Further Information and third party responses to concerns raised regarding the Proposed Coole WF, County Westmeath

Date: 05/09/2022

Tobar Archaeological Services Ltd prepared the archaeology and cultural heritage chapter of the EIAR which accompanied the planning application for the proposed Coole Wind Farm, County Westmeath. This document consists of a response to a request for Further Information (ABP Ref 309770-21 issued by An Bord Pleanála as well as addressing third party concerns.

Figure 13-21: Unnamed bridge on  $\mathcal{L}^{nd}$  edition 25 inch OS map in relation to proposed access road to T15.

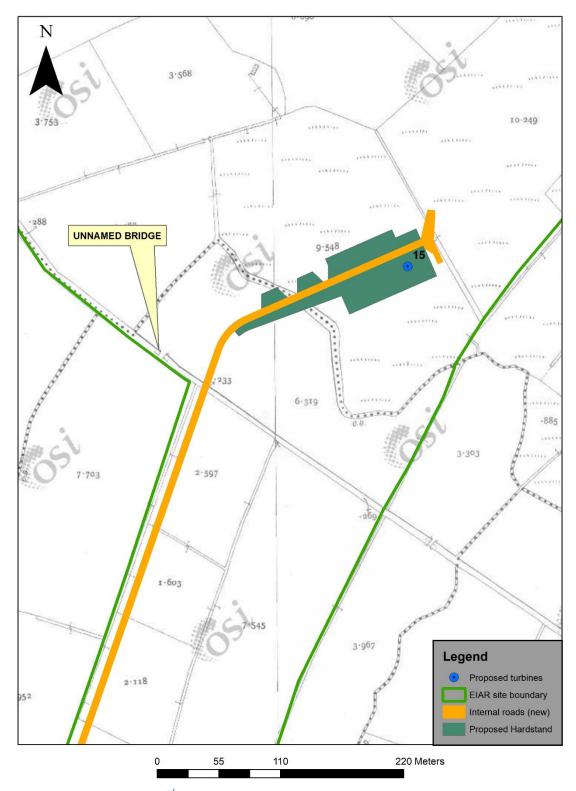
Several submissions refer to the lack of mitigation measures regarding archaeological heritage in Chapter 3 of the EIAR. Chapter 13 of the EIAR provides a comprehensive assessment of potential impacts on archaeology and cultural heritage as a result of the proposed development. It also outlines appropriate mitigation measures in relation to the recorded and unrecorded archaeological, architectural and cultural heritage resource (see section 13.4.3 for mitigation measures regarding construction phase potential (direct) impacts). In summary the mitigation proposed in Chapter 13 include the following:

- Buffer zone of 20m around the unnamed bridge on the River Glore.
- Pre-construction building survey of the stone structure adjacent to the proposed link road and monitoring of ground works during the construction phase of the project

Figure 13-25: Detail of RMPs, Mayne townland adjacent to Grid Connection Route.

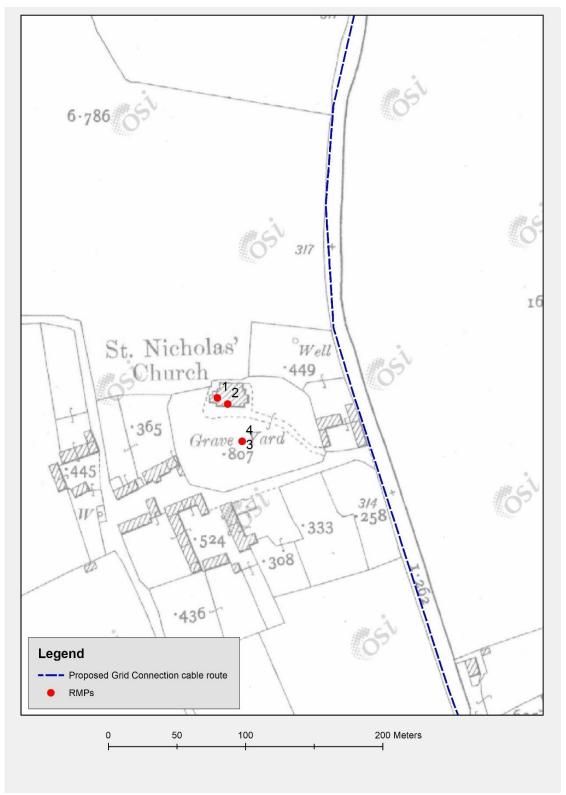
It is also suggested in a submission that archaeological monitoring is inadequate mitigation where the grid connection extends past Mayne church, font, graveyard and ecclesiastical enclosure (WM003-083---, WM003-083001-, 002- and 003-) and that the presence of a possible ecclesiastical enclosure around the church may suggest that a further outer enclosure is located under the public road along which the grid connection will extend. It is noted in the monument description (WM003-083003-) that 'the semi-curving form of the graveyard boundary wall possibly indicates the presence of an Early Christian ecclesiastical enclosure'. The graveyard boundary wall is situated c. 21.5m to the west of the proposed grid connection route. A review of the available cartographic and orthophotography sources does not provide any evidence for a further outer enclosure. It is considered, therefore that archaeological monitoring of ground works along the grid connection route where it extends past the church, graveyard and possible ecclesiastical enclosure is adequate mitigation. As outlined above, monitoring of the works associated with the grid connection route will be carried out under licence from the National Monuments Service (NMS) of the DHLGH. A methodology pertaining to the archaeological monitoring will be subject to the approval of the NMS and any remains uncovered during the course of the works (if present) will be reported to the NMS as per the agreed methodology in order to agree the best course of action and any further mitigation (such as excavation) required in this regard. A report detailing the results of the monitoring and any findings will be compiled on completion of the works and submitted to the relevant authorities.

Figure 13-28: RPS structures within 100m of the proposed Grid Connection Route at Ballynafid and Farranistick.

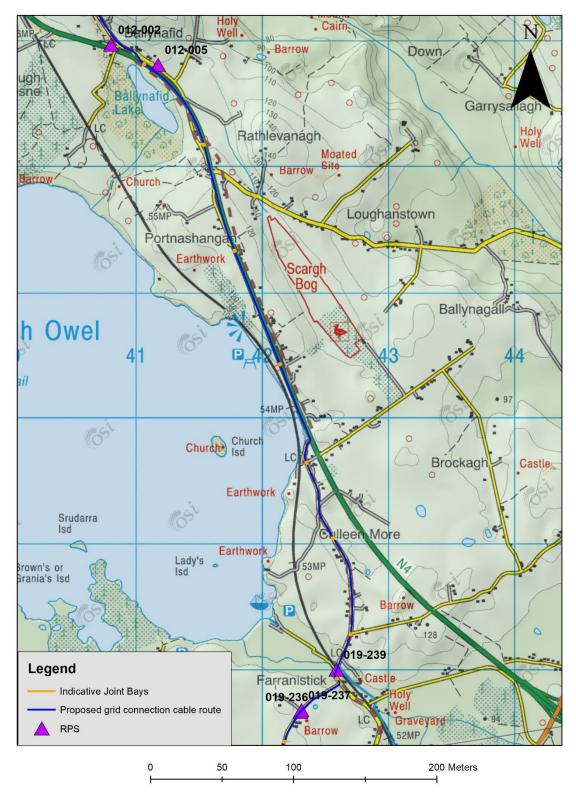
Concerns regarding the proximity of some Protected Structures to the proposed grid connection route are raised in a number of submissions. As outlined in Chapter 13, Section 13.3.2.2.1 (Table 13-7) twenty structures listed in the RPS for County Westmeath are located within 100m of the proposed grid connection route. The closest protected structure to the Grid Connection Route comprises Levington railway crossing gates which are located on the public road along which the proposed Grid Connection Route extends. The level crossing gates are 19th century in date being part of the Dublin-Sligo railway line and are still in active use. In Coole, Simonstown House (Ref. 003-042) is situated off-road in private property and will not be directly impacted by the works associated with the Grid

Connection Route which will be placed within the public road c. 38m to the north-west. Other protected structures in close proximity to the proposed Grid Connection Route comprise the gate lodge (Ref. 019-237) and gateway (019-236) to Levington Park house which is also included in the Record of Protected Structures (Ref. 019-234). The house is situated c. 130m to the north-west of the proposed underground Grid Connection Route in private property and will not be impacted by works associated with the underground cable. The roadside features associated with the house as mentioned above are situated within 2-4m of the proposed Grid Connection Route which will extend along the adjacent public road. While it is unlikely that any direct impacts to these structures will occur as a result of the proposed Grid Connection Route some mitigation at the construction stage of the Proposed Development is recommended for this area as follows (see Chapter 13 Section 13.4.3.6.3):

- Archaeological monitoring of ground works during construction where they extend past the NIAH/Protected Structures at Farranistick. A report on the results of the monitoring shall be compiled and submitted to the relevant authorities on completion of the project.
